**KIRKLEES COUNCIL
TOWN AND COUNTRY PLANNING ACT 1990
HIGHWAYS DEVELOPMENT MANAGEMENT**

PLANNING REF 2017/60/90207/W0/MW
CATEGORY Small Major

PROPOSAL OUTLINE APPLICATION FOR
ERECTION OF B1 LIGHT INDUSTRY

LOCATION THONGSBRIDGE MILLS
MIRY LANE
THONGSBRIDGE
HOLMFIRTH
HD9 7RW

GENERAL NOTES:

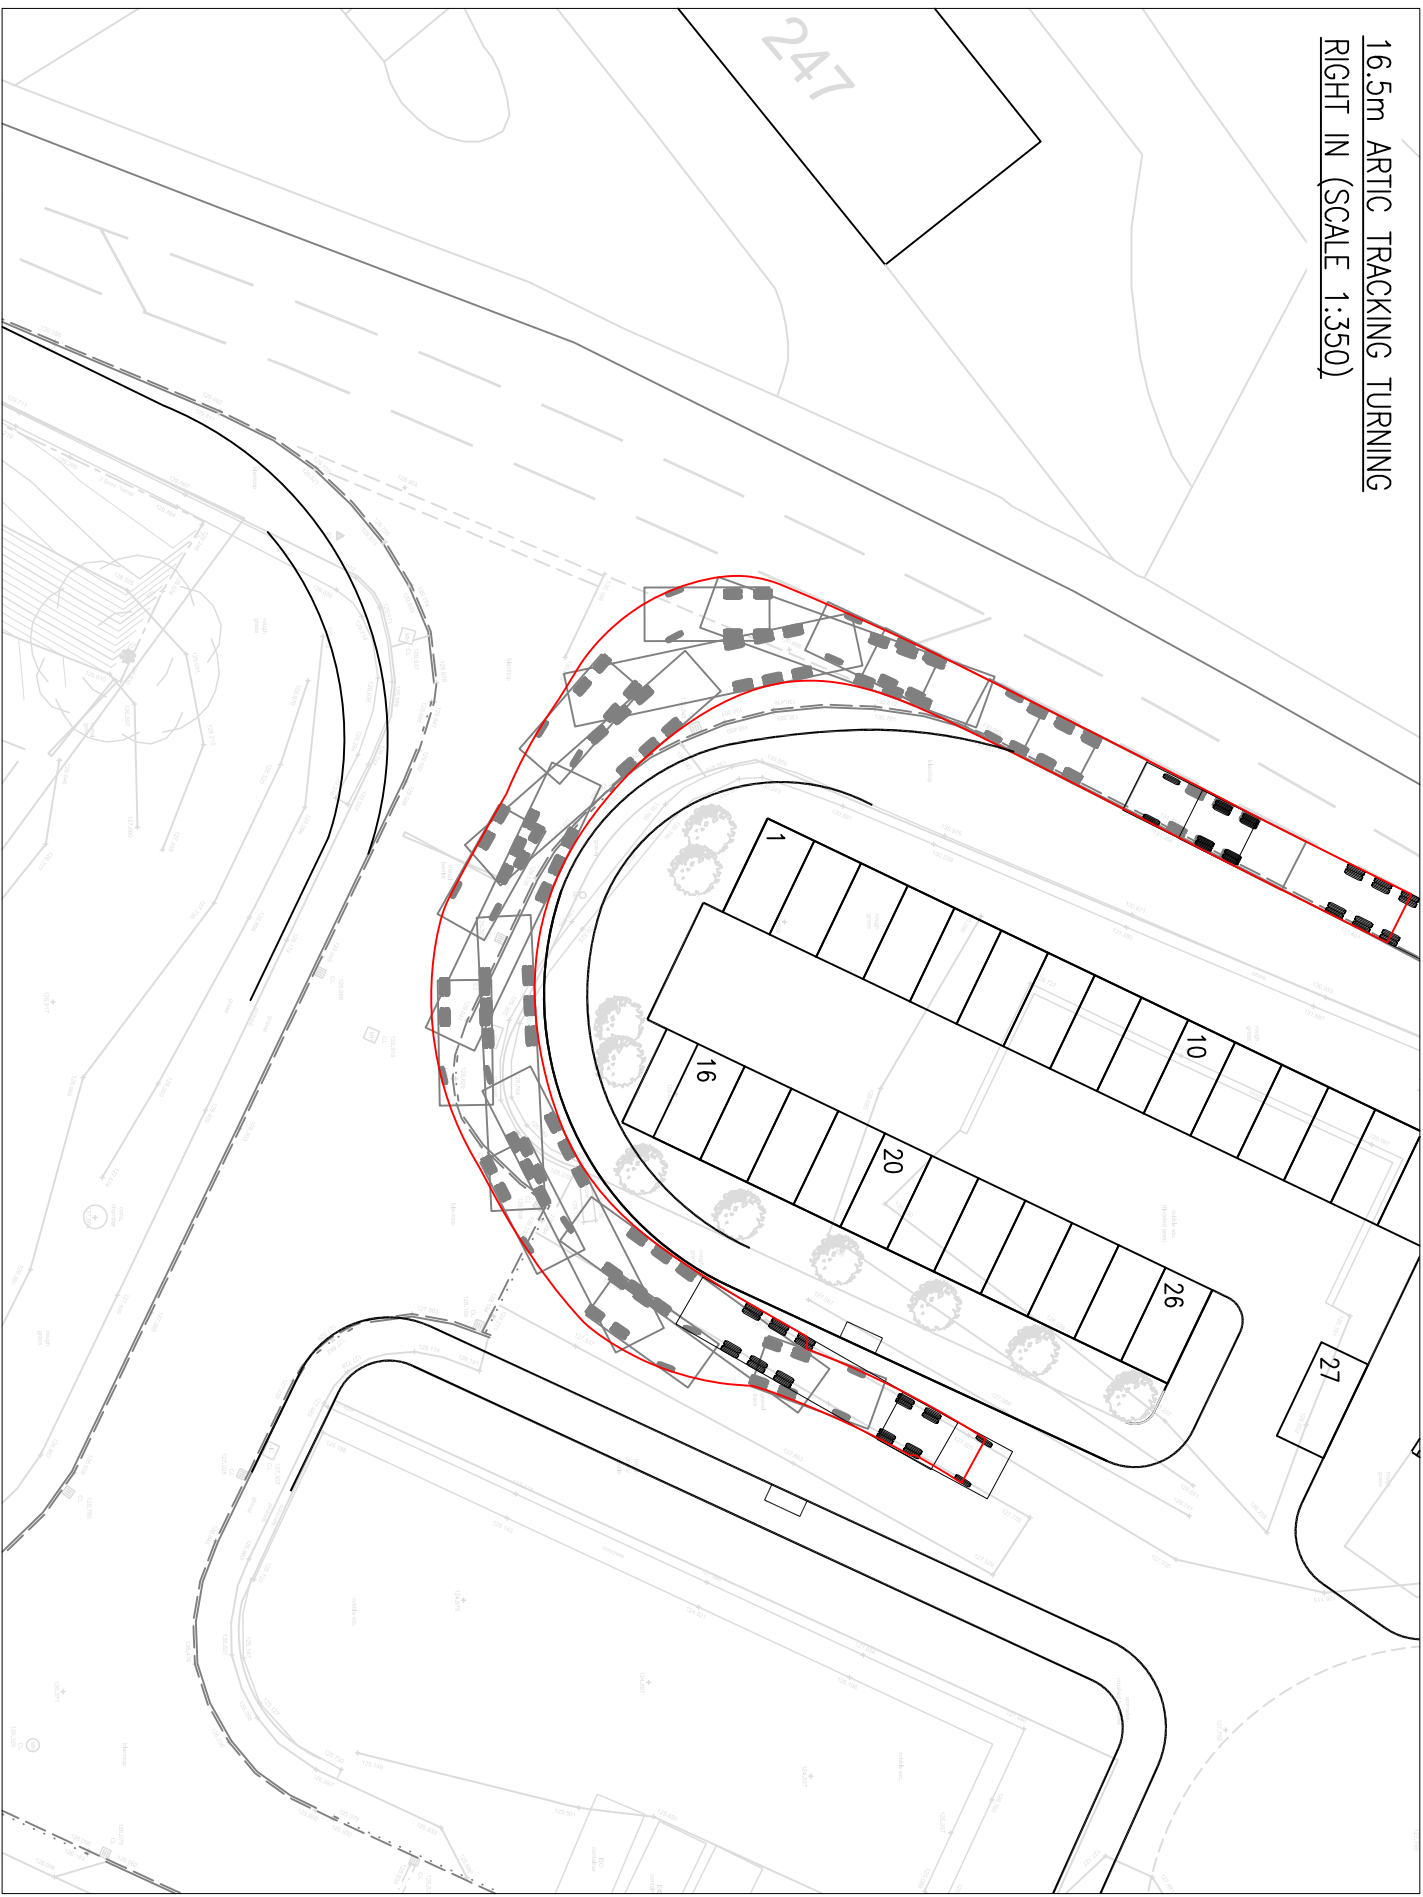
The applicants revised plan number 1212-101 rev B (articulated vehicle tracking) which shows that a 16.5 metre articulated vehicle can undertake all movements satisfactorily. Whilst this plan is considered acceptable Highways have concerns regarding the increased width of the access onto Huddersfield Road and the implications for pedestrian. A pedestrian traffic island is therefore considered necessary to assist pedestrian movements across the proposed widened access.

With reference to plan no 1212-101 rev B, the development shall not commence until a scheme detailing the provision of a widened and improved site access from Huddersfield Road including the provision of a pedestrian island, visibility splays, construction specification, surfacing, drainage, white lining and signing and kerbing and associated highway works together with independent Safety Audits covering all aspects of the work has been submitted and approved in writing by the Local Planning Authority. The development shall not be brought into use until the approved scheme has been implemented and thereafter retained throughout the lifetime of the development.
